Our ref: Q210843
Your ref: 22/00747/OUT
Email: gregory.markes@quod.com
Date: 31 May 2022

Representation in respect of planning application for Land at Bicester Road, Kidlington known as 'PR7a' (LPA reference 22/00747/OUT)

Transport Assessment

Figure 3-2: PIC Study Area

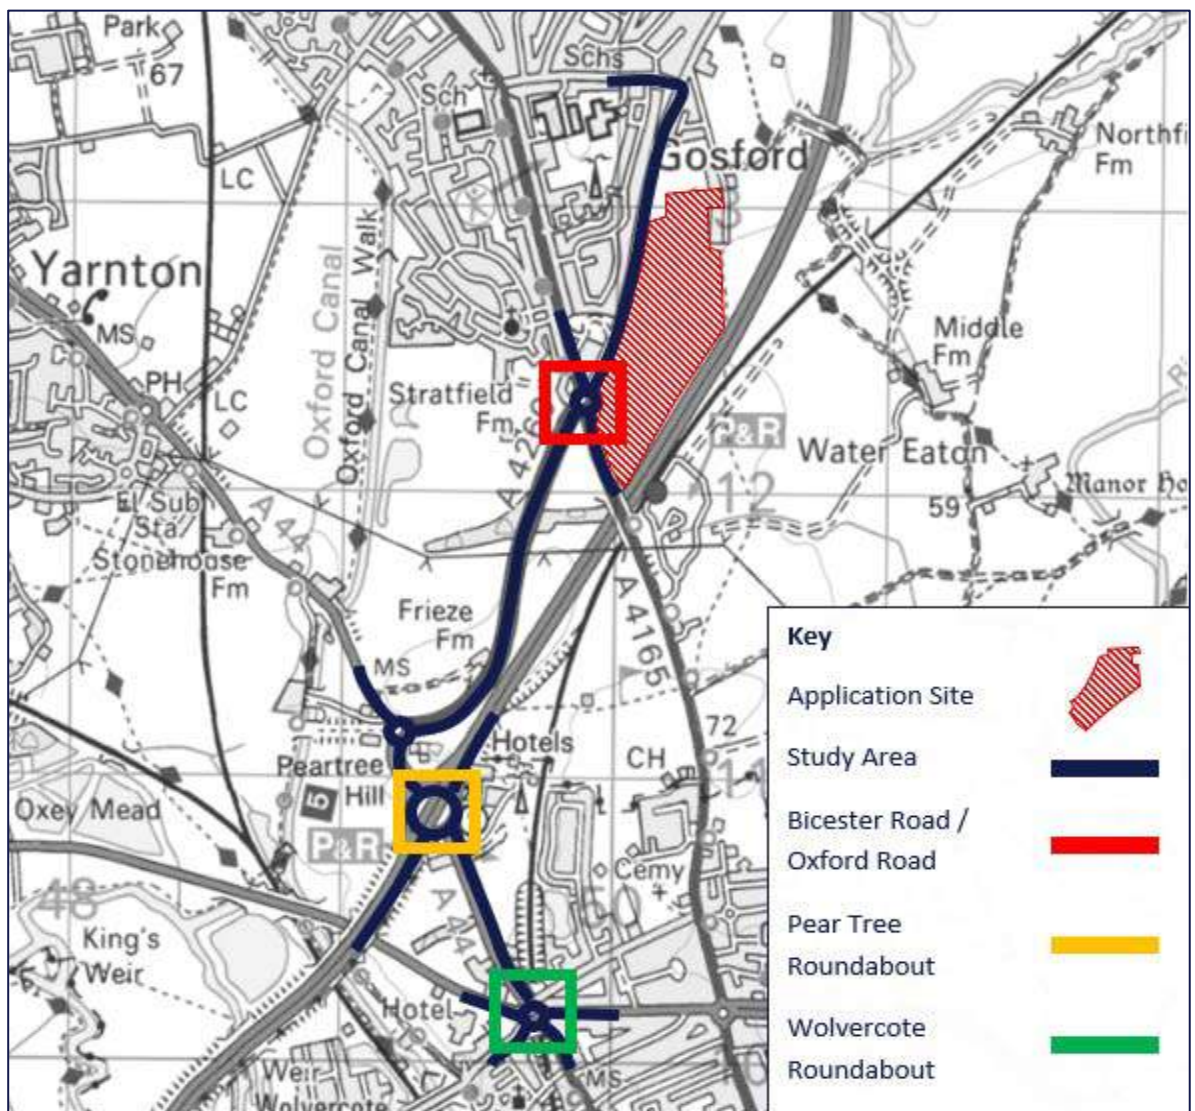
- ii. The Highway Safety Review should include an assessment of the Cuttleslowe Roundabout, which is a key junction between the Kidlington and Oxford and one that experiences high levels of congestion.

- iv. The Highway Safety Review concludes with regard to the Bicester Road / Oxford Road roundabout that *“the PIC data does not indicate that there is an obvious highway safety problem associated with the roundabout.”* Such a conclusion contradicts not only the data within the TA itself (which is not considered up to date), but also overlooks the tragic death of a cyclist on this roundabout earlier this year. This roundabout is a key junction for all the ‘PR’ sites, though perhaps none more so than for PR7a. The County Council’s draft Local Transport and Connectivity Plan sets out the need to substantially increase the number of journeys made by bicycle. The Application, in its current form, would not create the conditions necessary to encourage people to travel by bicycle, which relies on providing a safe network of cycle paths. For this Application to be found acceptable by the Council, we consider it essential that provision is made in the section 106 obligation for fair and reasonable contributions to be made to comprehensive improvements to an agreed plan for this roundabout.
